# CONSTRUCTION DOCUMENTS

# WINDERMERE FILING NO. 1

CONSTRUCTION DOCUMENTS FOR  
**WINDERMERE**  
**FILING NO. 1**  
N. MARKSHEFFEL ROAD  
EL PASO COUNTY, COLORADO

ISSUE	DATE
INITIAL ISSUE	6-18-21
RESUBMITTAL	8-30-21

NT02

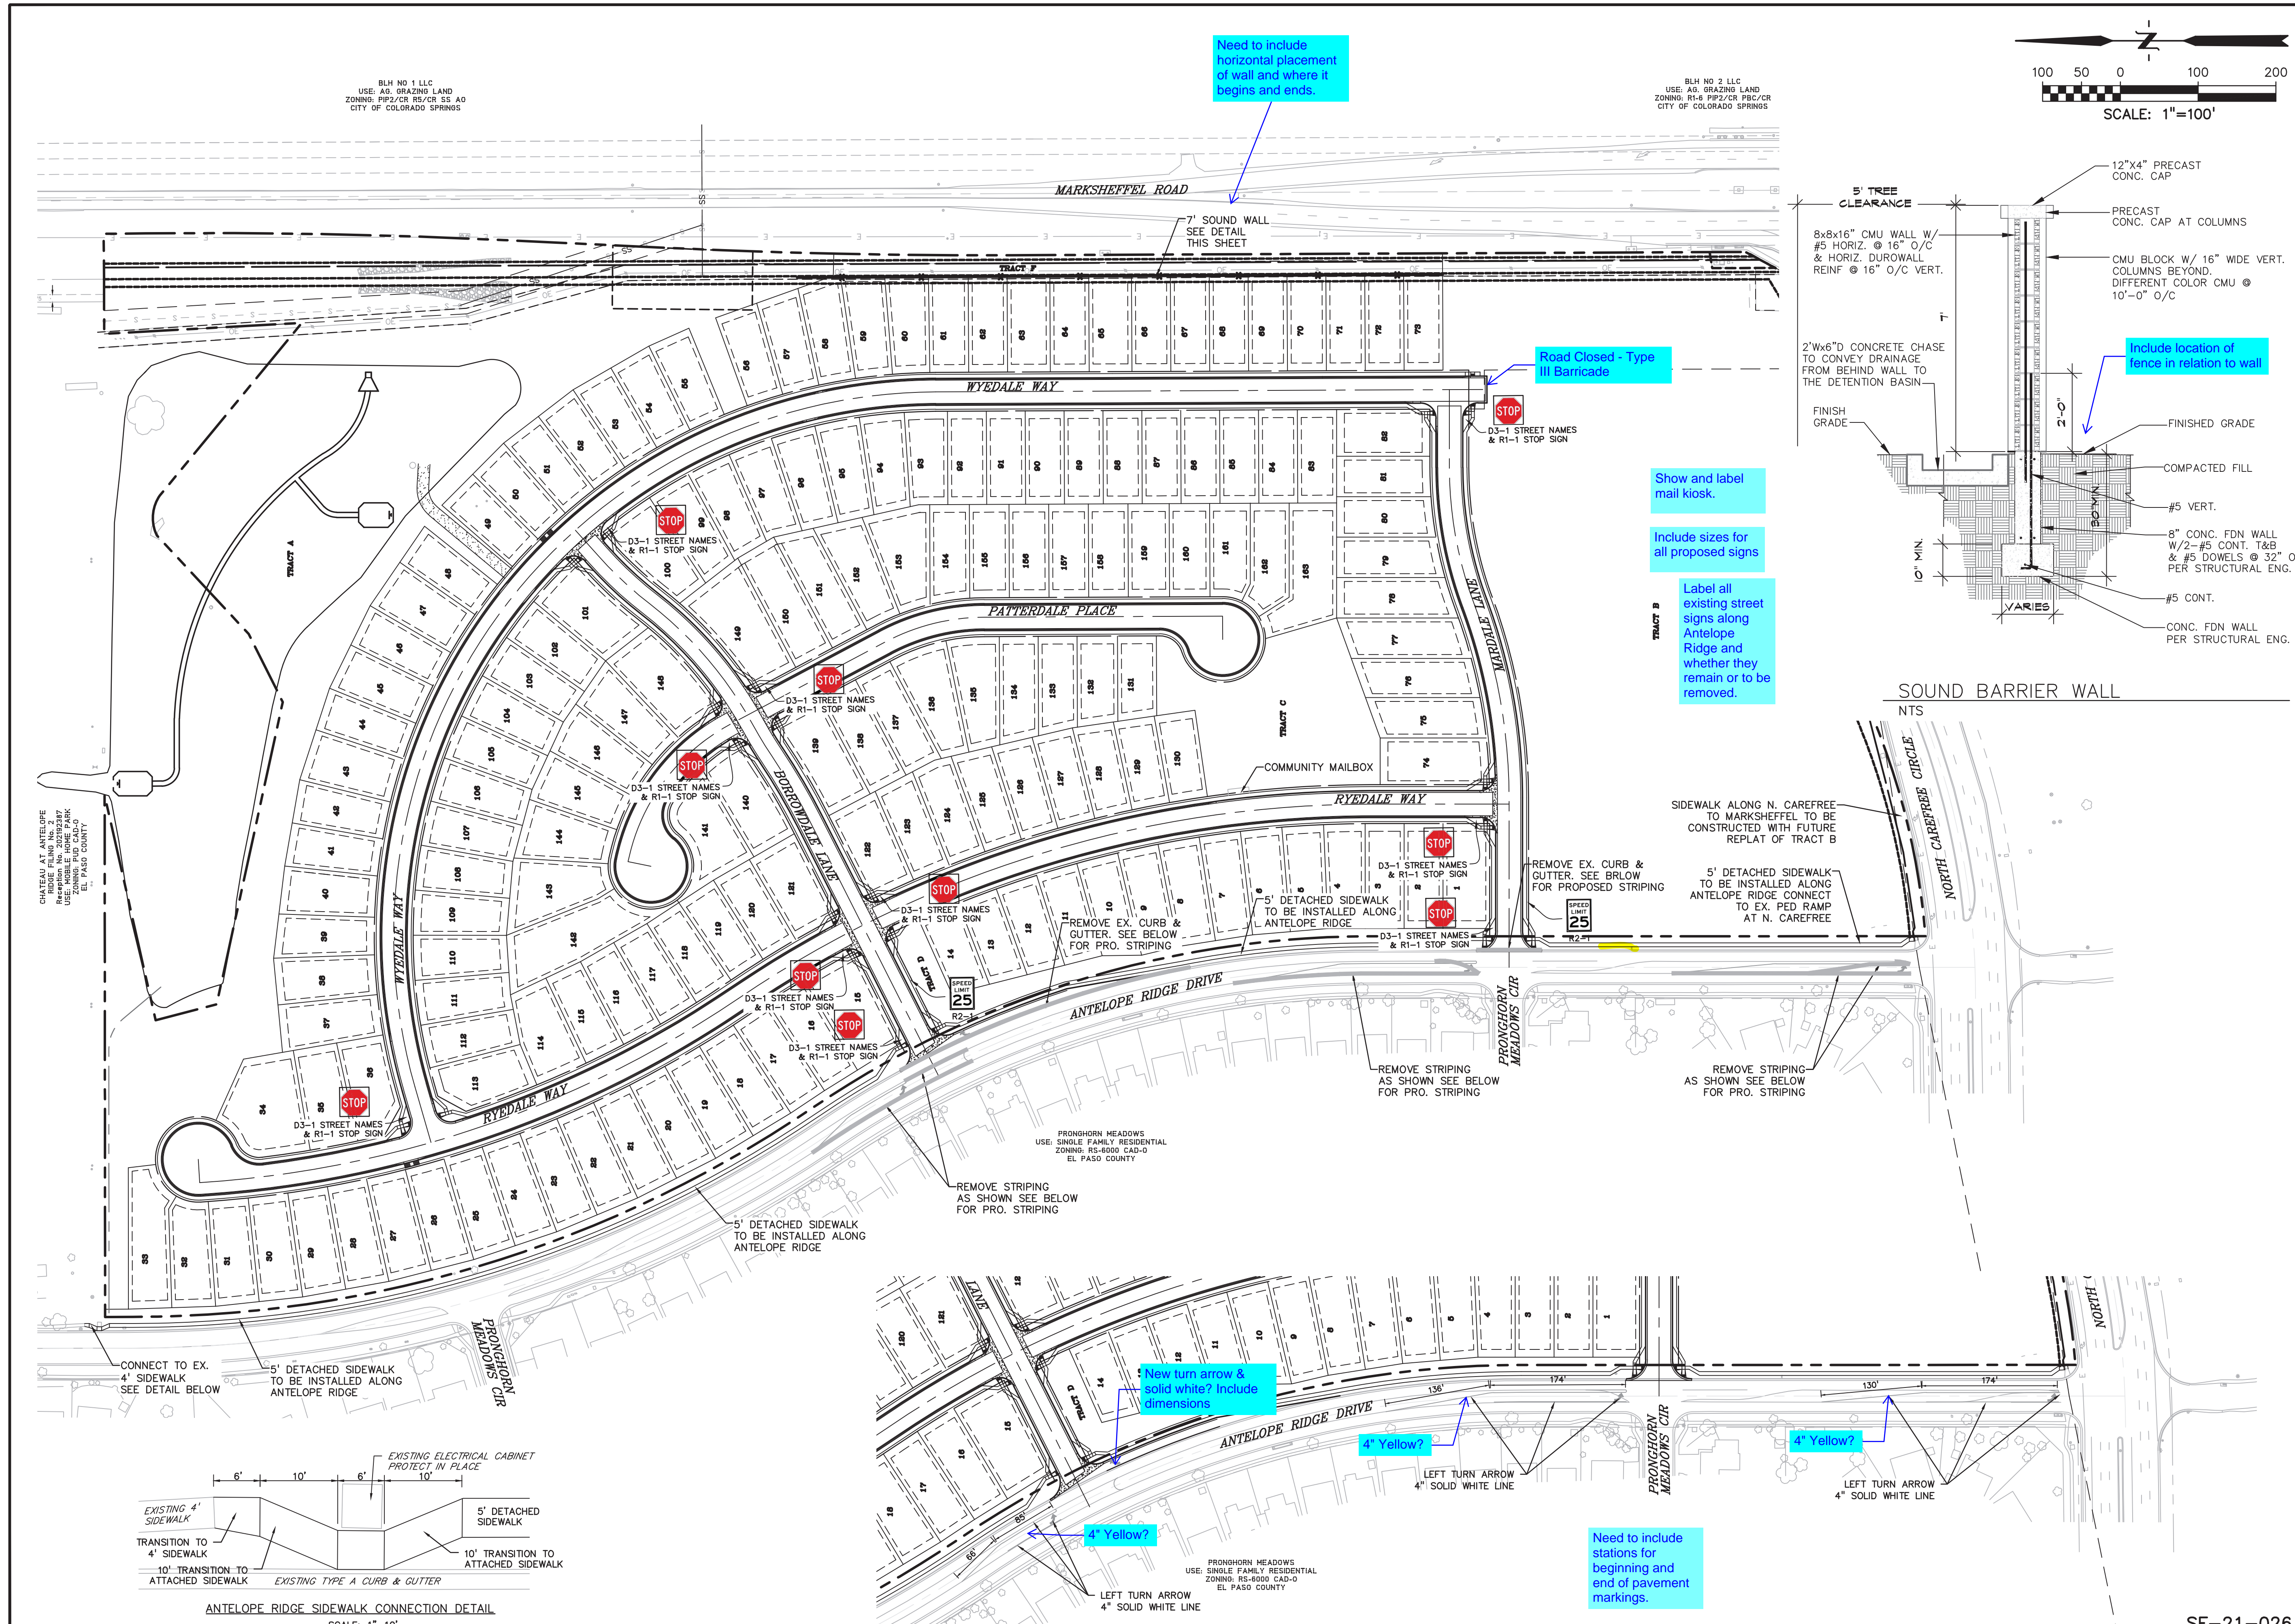
Please provide the standard road cross-section.
